Town & Country Planning Act 1990 (as amended)
Town and Country Planning (Development Management Procedure) (England) Order 2015

Two-storey extension to the existing Cafe in order to provide increased internal seating, multi-purpose space, with improved service & food preparation area, disabled access & bike storage.

The Bluebird Cafe South Drive Ferring

Ref: Bluebird Caf Planning Application

01 PROPOSED NORTH ELEVATION  
2003 Scale: 1:100

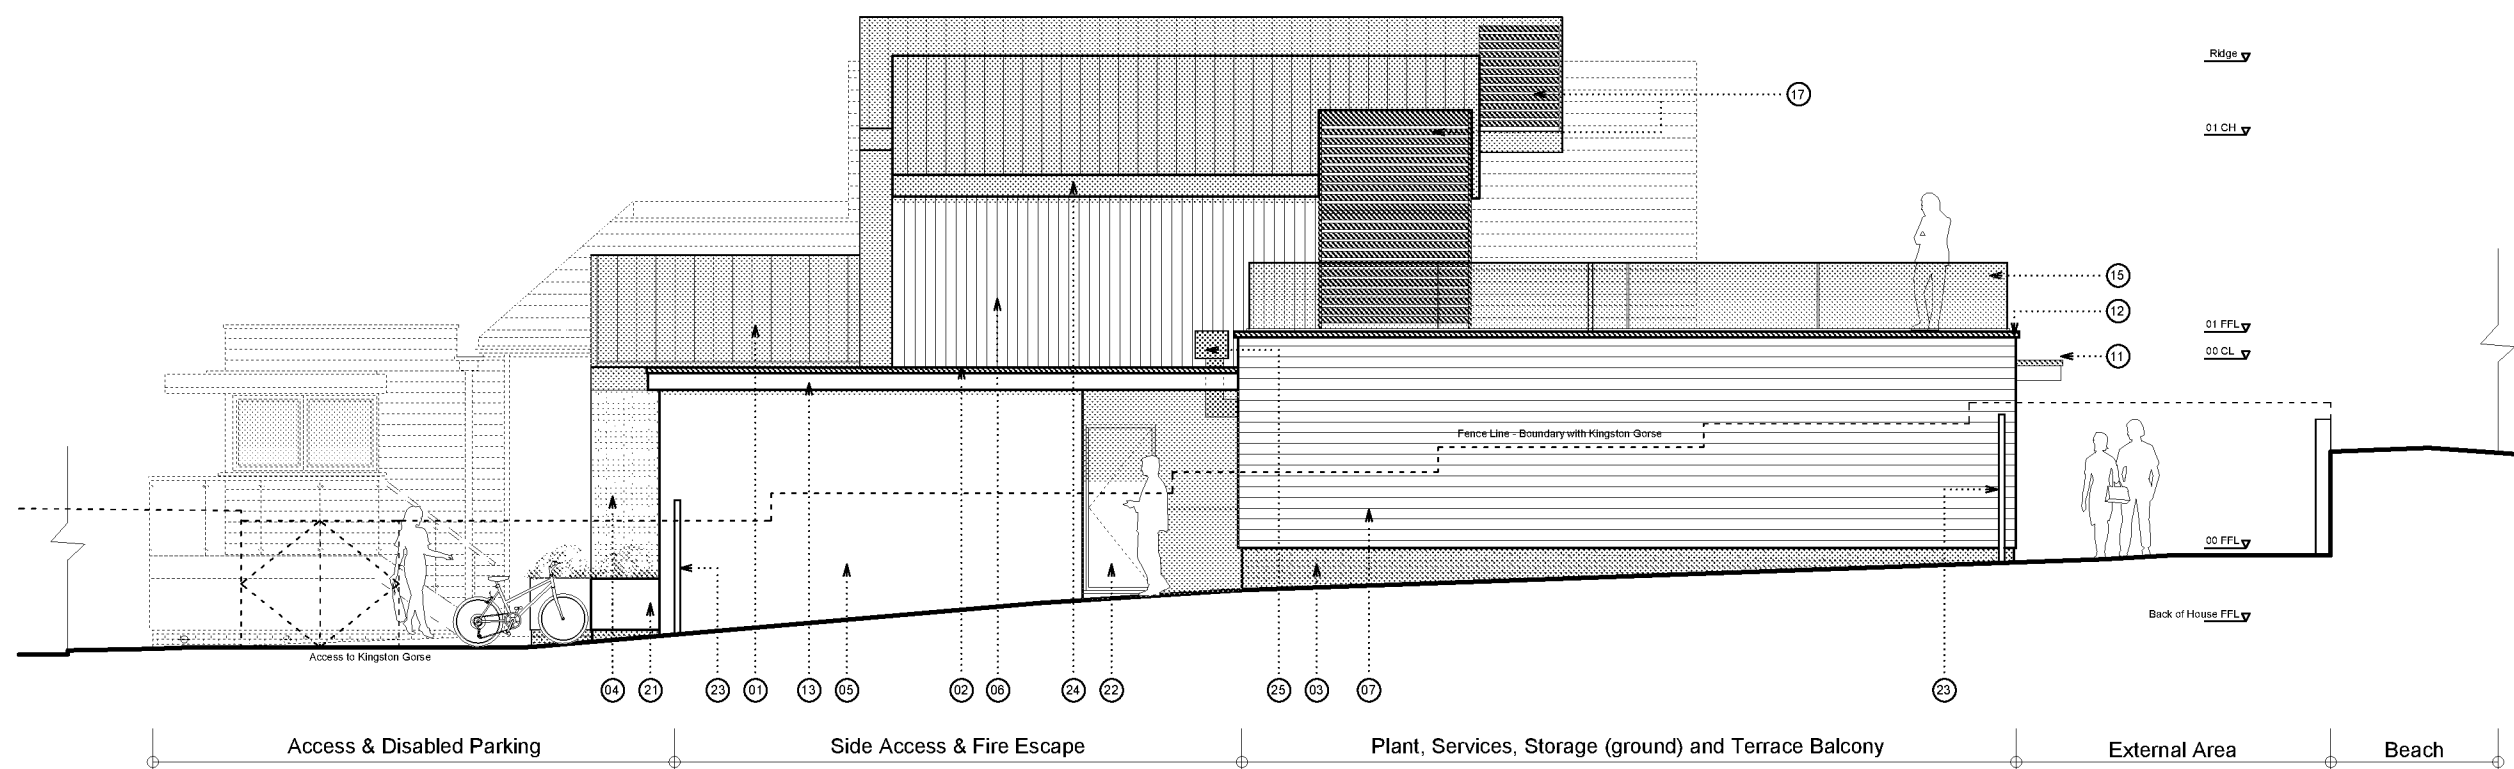
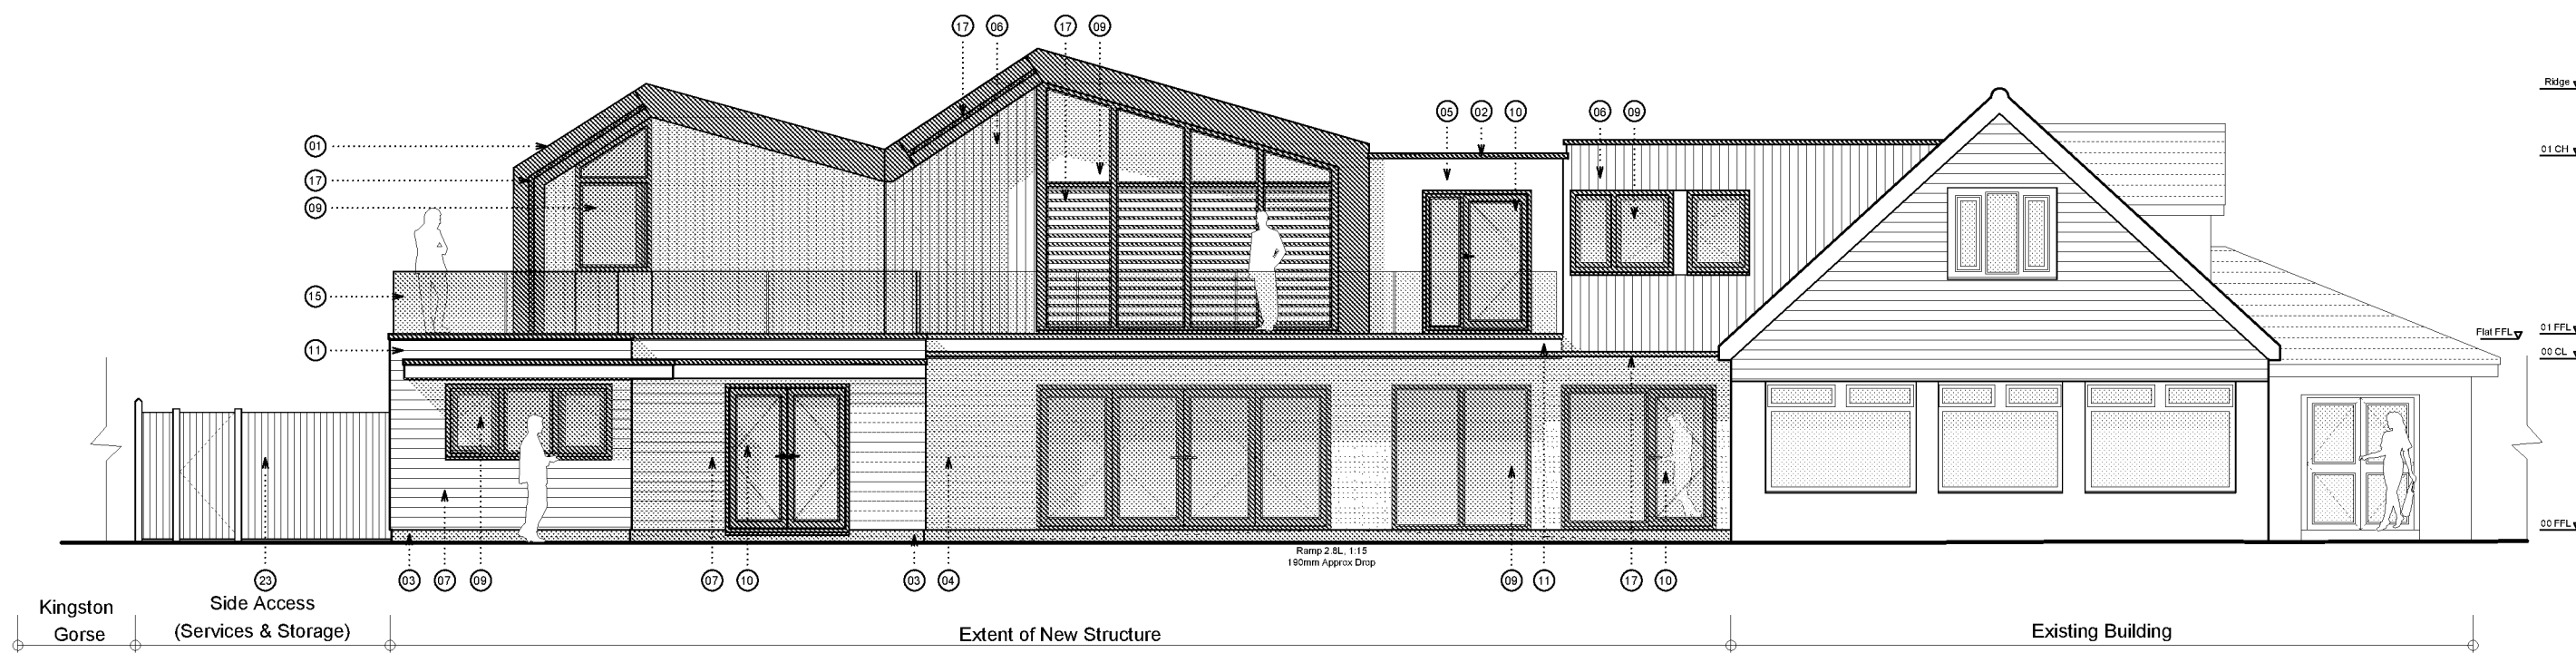
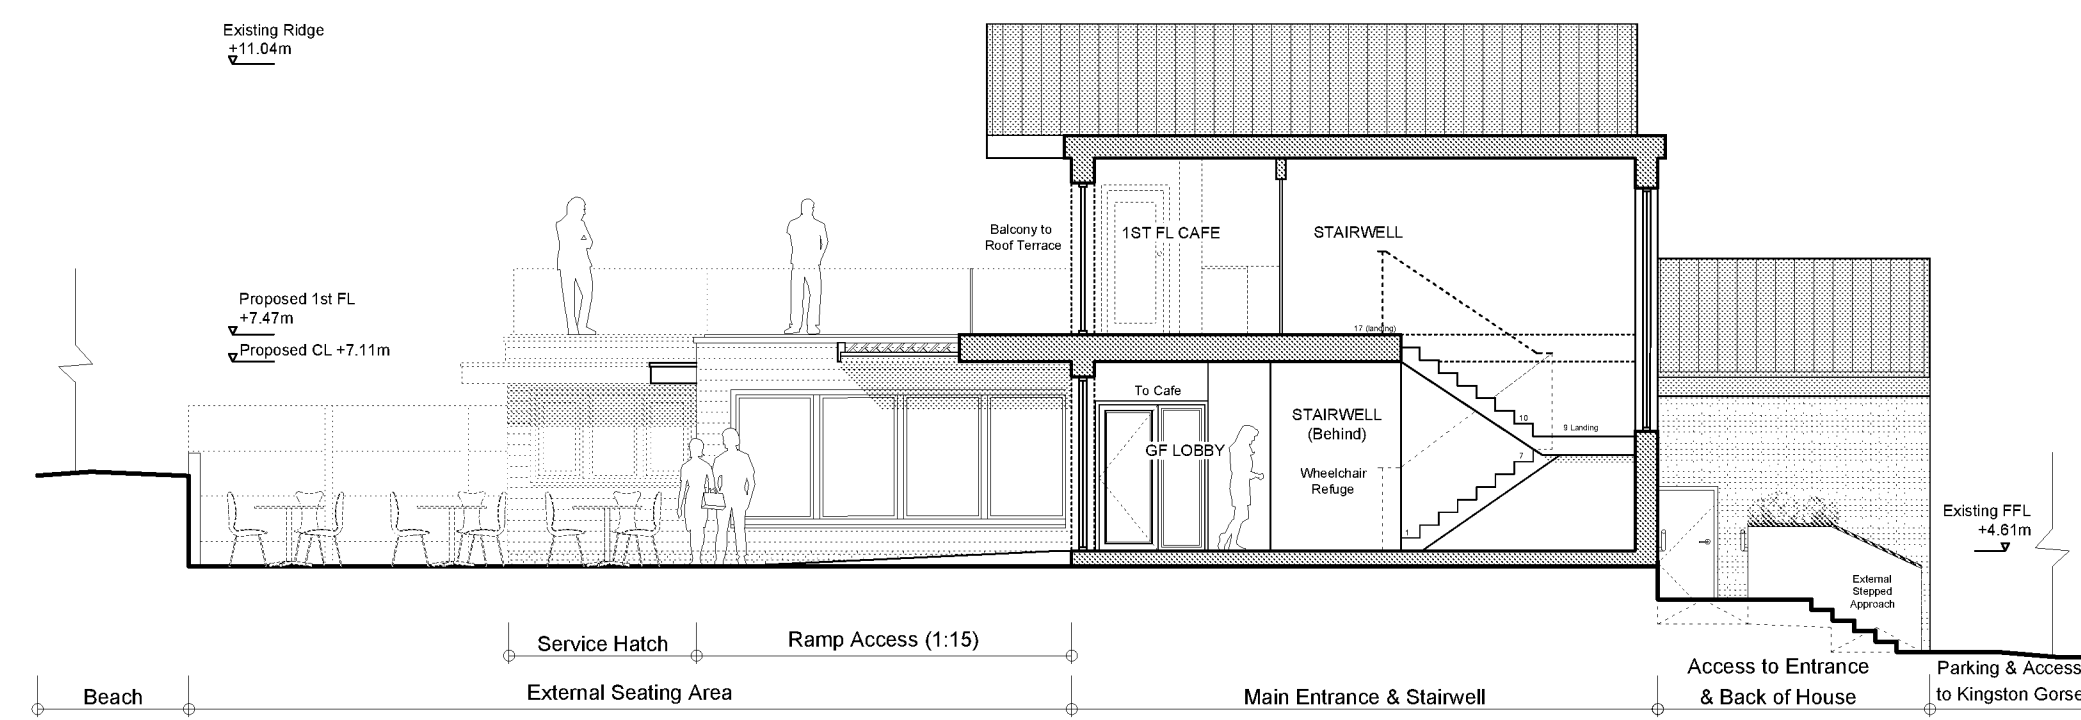
a) Overlooking: The first-floor balconies in the new development will overlook the properties to the west.

b) Privacy: The windows and balconies facing west will cause a loss of privacy to adjacent properties.
